RFI #: 8
Date: 12/12/2011
Job: EB-02 Keller Springs Lofts
Phone: 877-777-5115

Subject: RFI Pier Dimensions

RFI #: 23
Date: 1/3/2012
Job: EB-02 Keller Springs Lofts
Phone: 877-777-5115

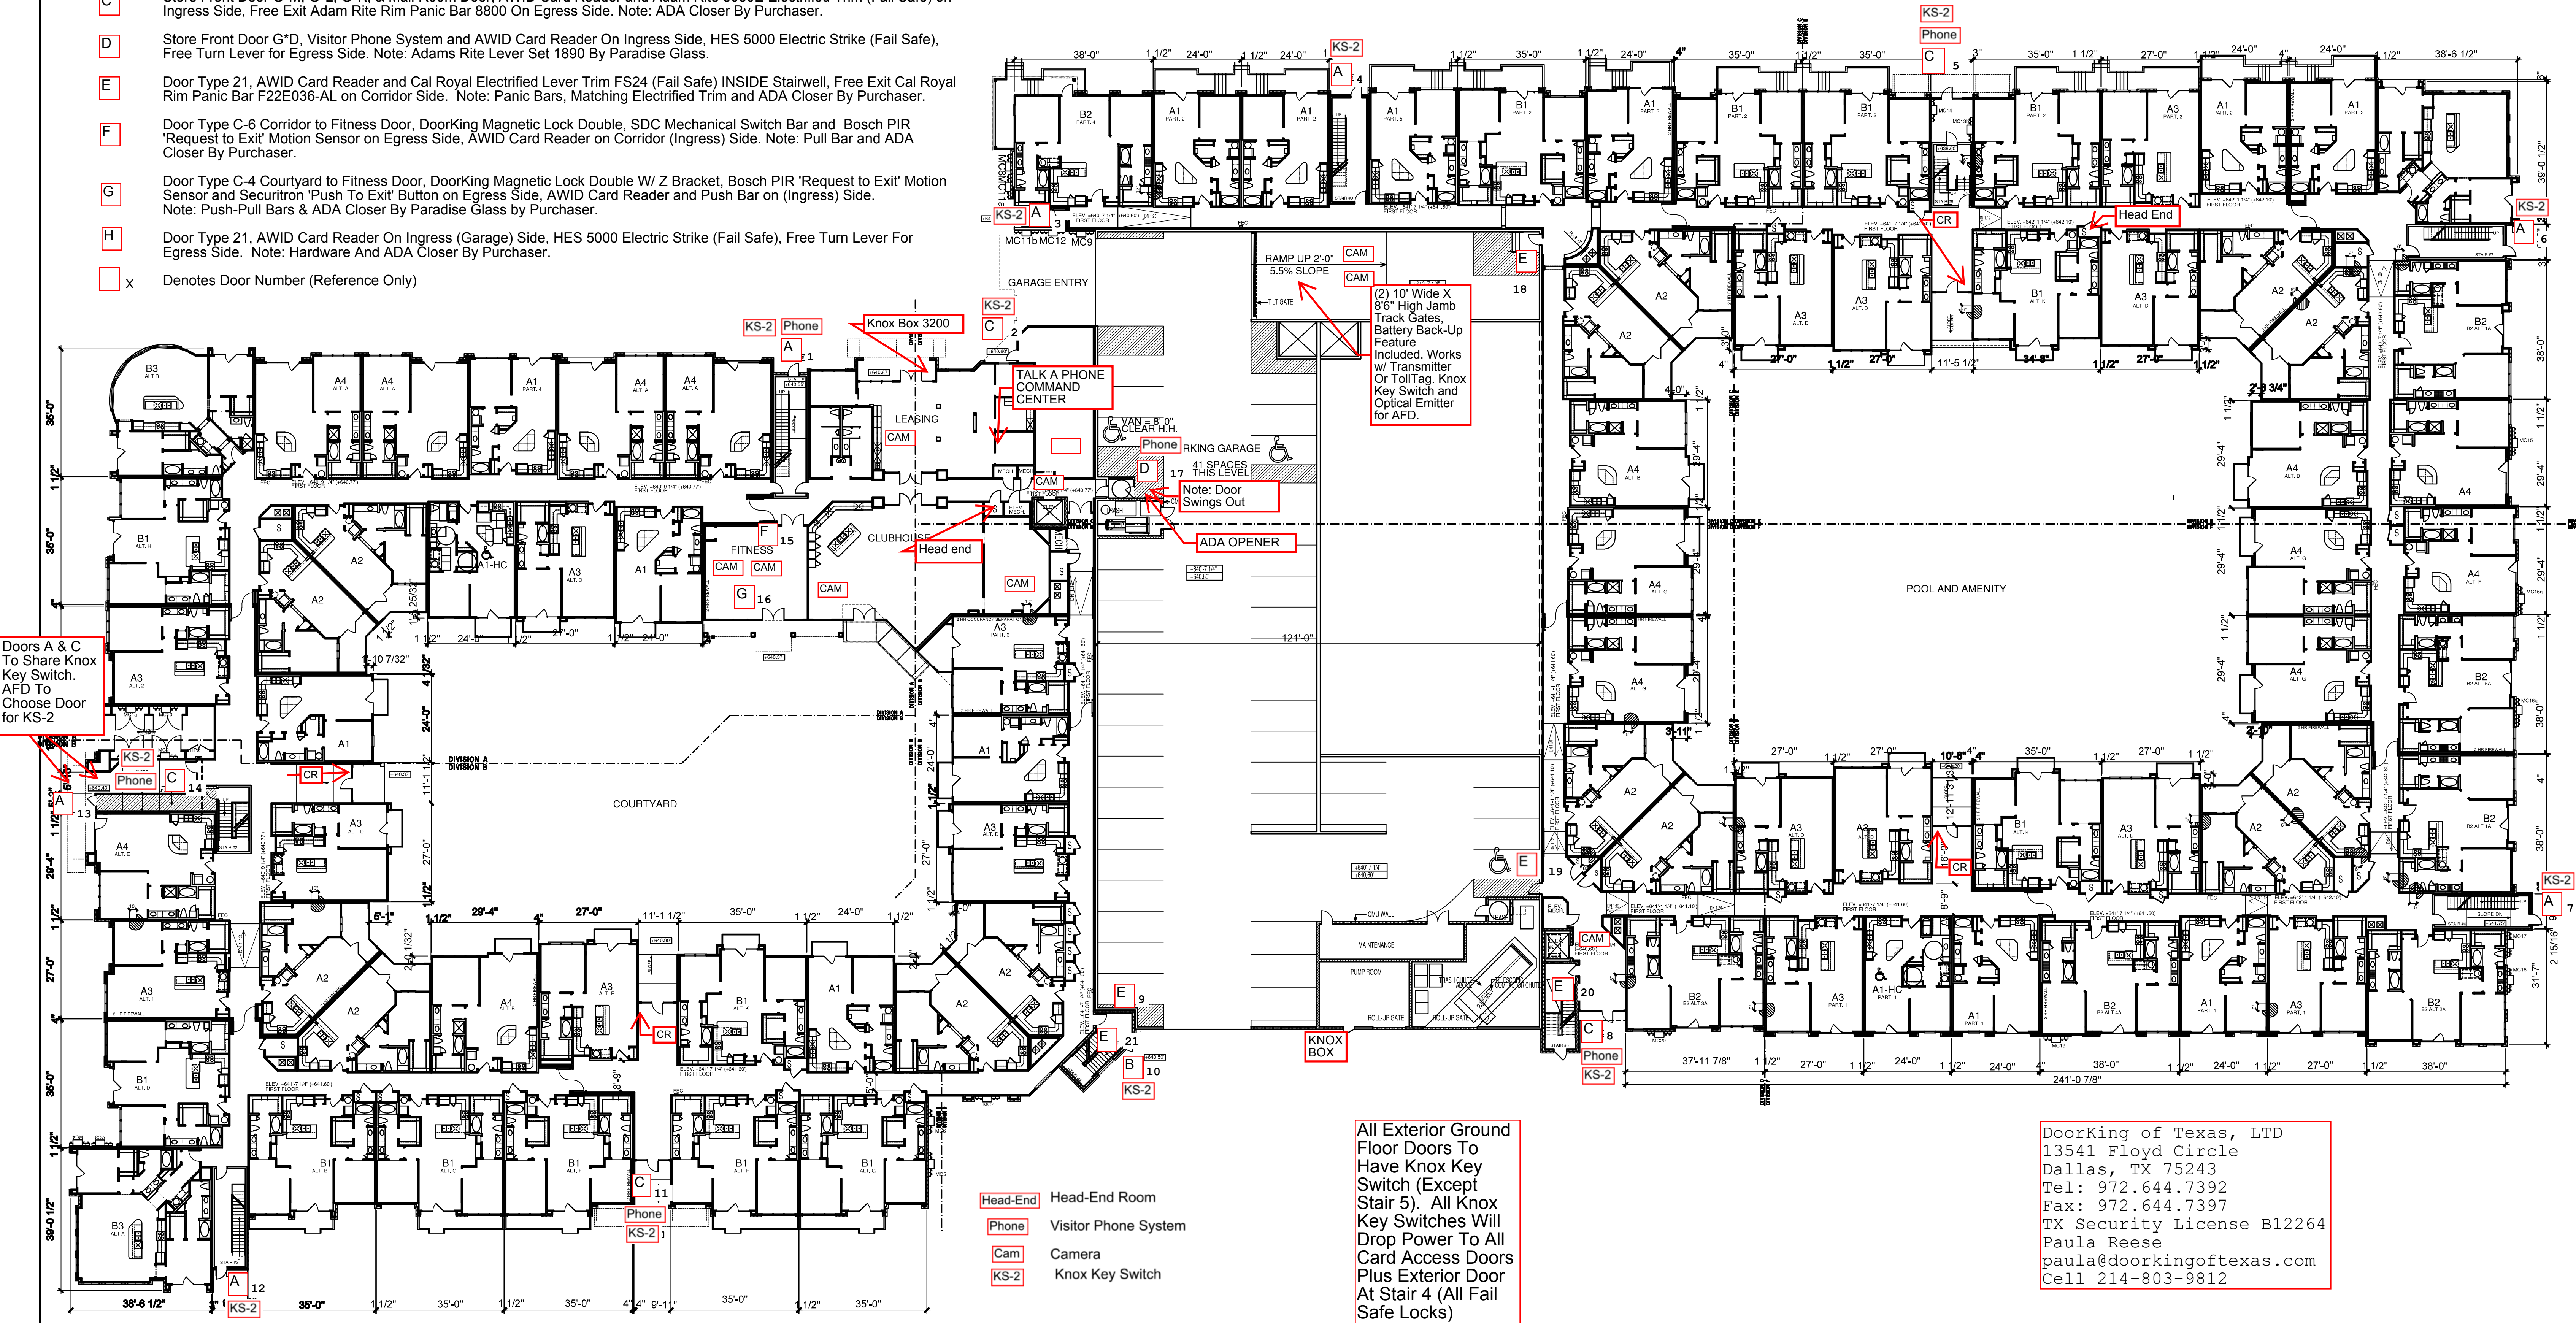
Request: Date Required: 12/21/2011
On SG 2.01 the maintenance and fire room on the parking garage do not coordinate with arch 3.1D. please give direction

Response:
Please see attached drawing SG2.01 - Revised 12/14/2011
Trent Perkins, P.E.
Principal
Parkin-Perkins-Olsen Consulting Engineering, Inc.
12-14-2011
